DOC17/627880
SSD 8573

Wellington Solar Farm - SSD 8573

OEH review of Wellington Solar Farm EIS

Figure 8. Overview of recorded sites.

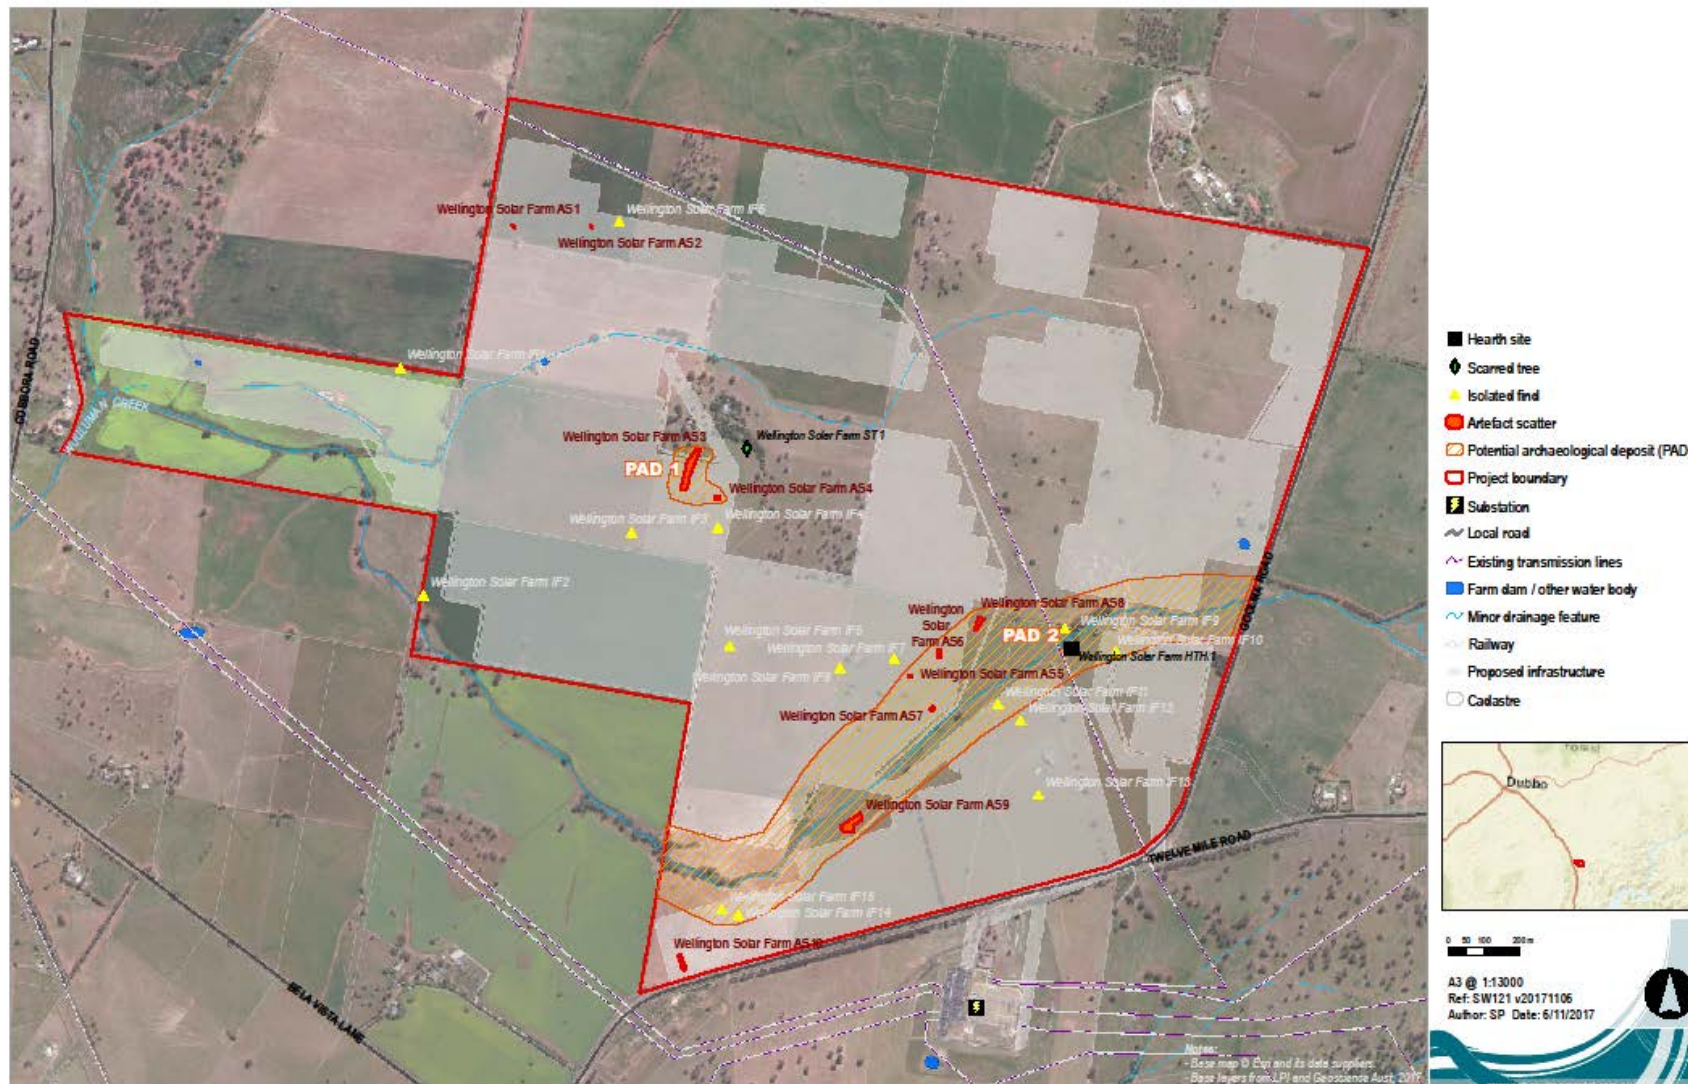
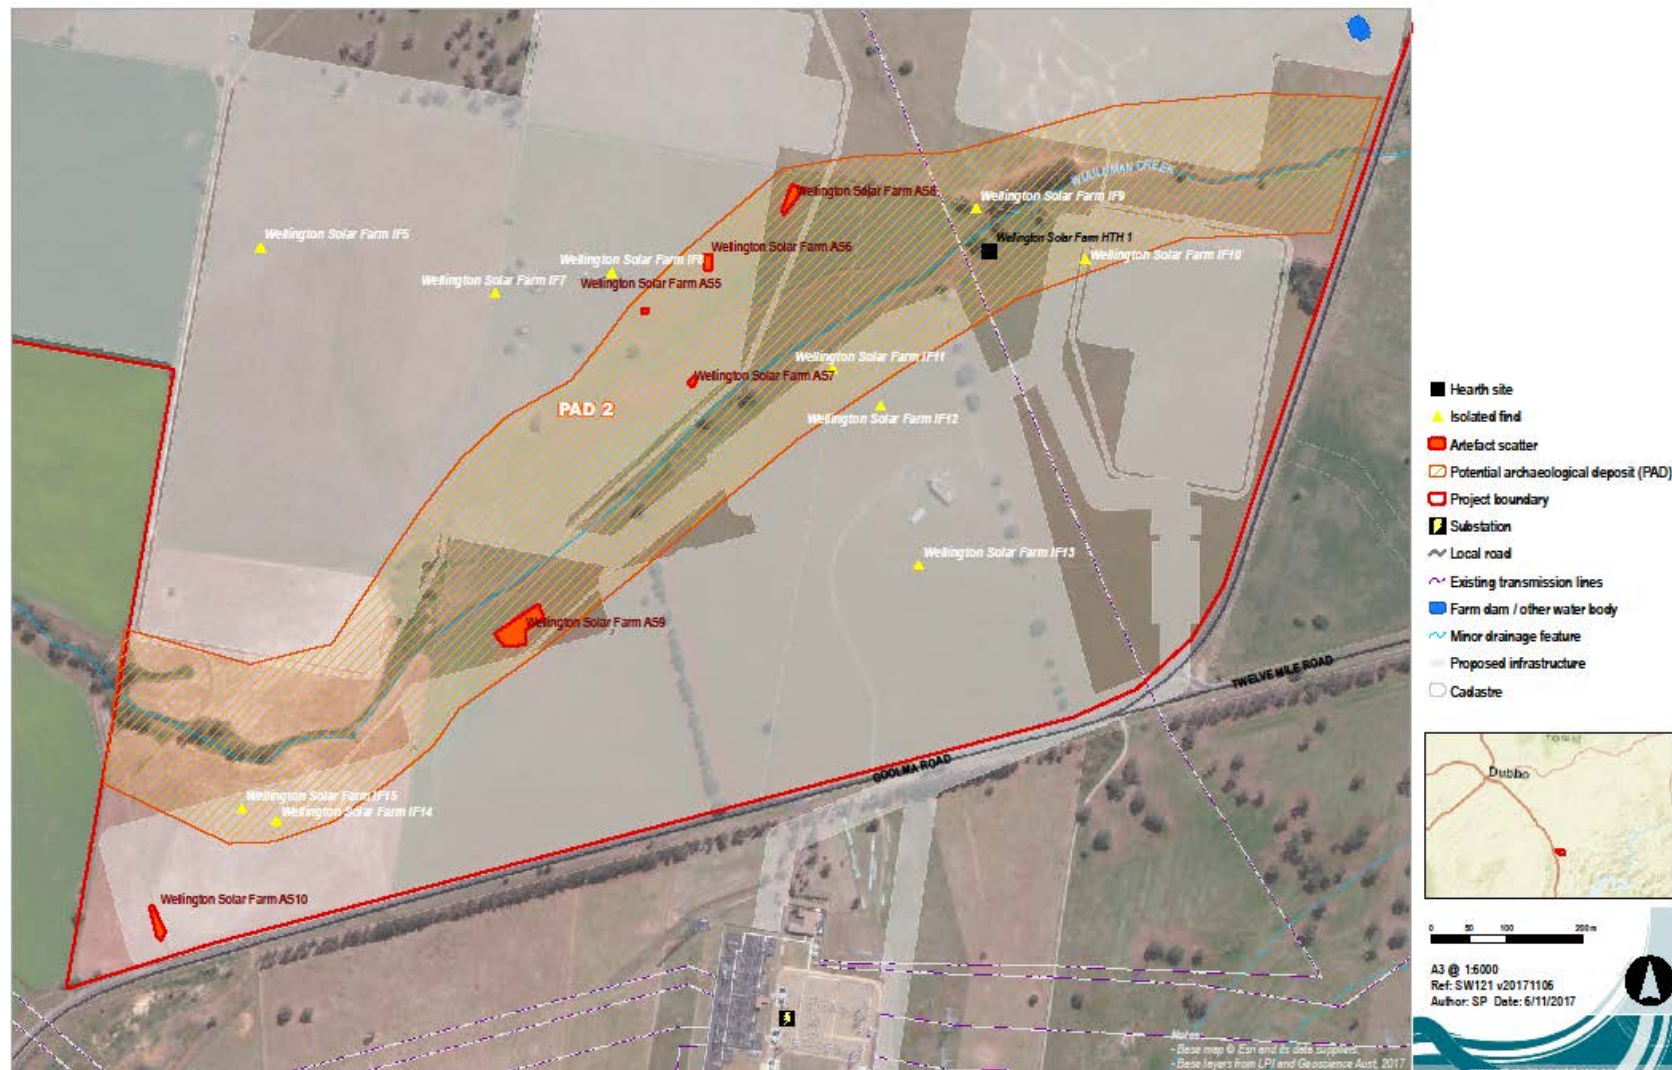
OEH has not sighted convincing scientific evidence to support the need for test excavations at PADs 1 and 2.

The information provided in the ACH assessment highlights the low significance of the Aboriginal objects and the intense land use disturbance history across the project area. The archaeological descriptions indicate limited opportunities for subsurface discoveries of high significance.

Test excavations are generally reserved for circumstances where supporting information indicates potential for significance of a location other than presence or absence of objects. A test program for the proposed Solar Farm project may offer disproportionate returns for ACH information of significance versus the costs incurred from undertaking the program.

Should the proponent propose a test excavation program, a supporting rationale and details of the proposal will need to be provided in the Cultural Heritage Management Plan. This will need to include descriptions of how the requirements for test excavation in the *Code of Practice for Archaeological Investigation of Aboriginal Objects* in NSW will be applied.

OEH will make further assessment of the test excavation proposal (outlined in recommendation 5 of section 9 of the ACH assessment) during consultation for the draft Cultural Heritage Management Plan.

- 2.1 The Cultural Heritage Management Plan should include a rationale for, and details of, any proposed ACH test excavations of PADs 1 and 2.
- 2.2 OEH is to be consulted regarding the development of the Cultural Heritage Management Plan.
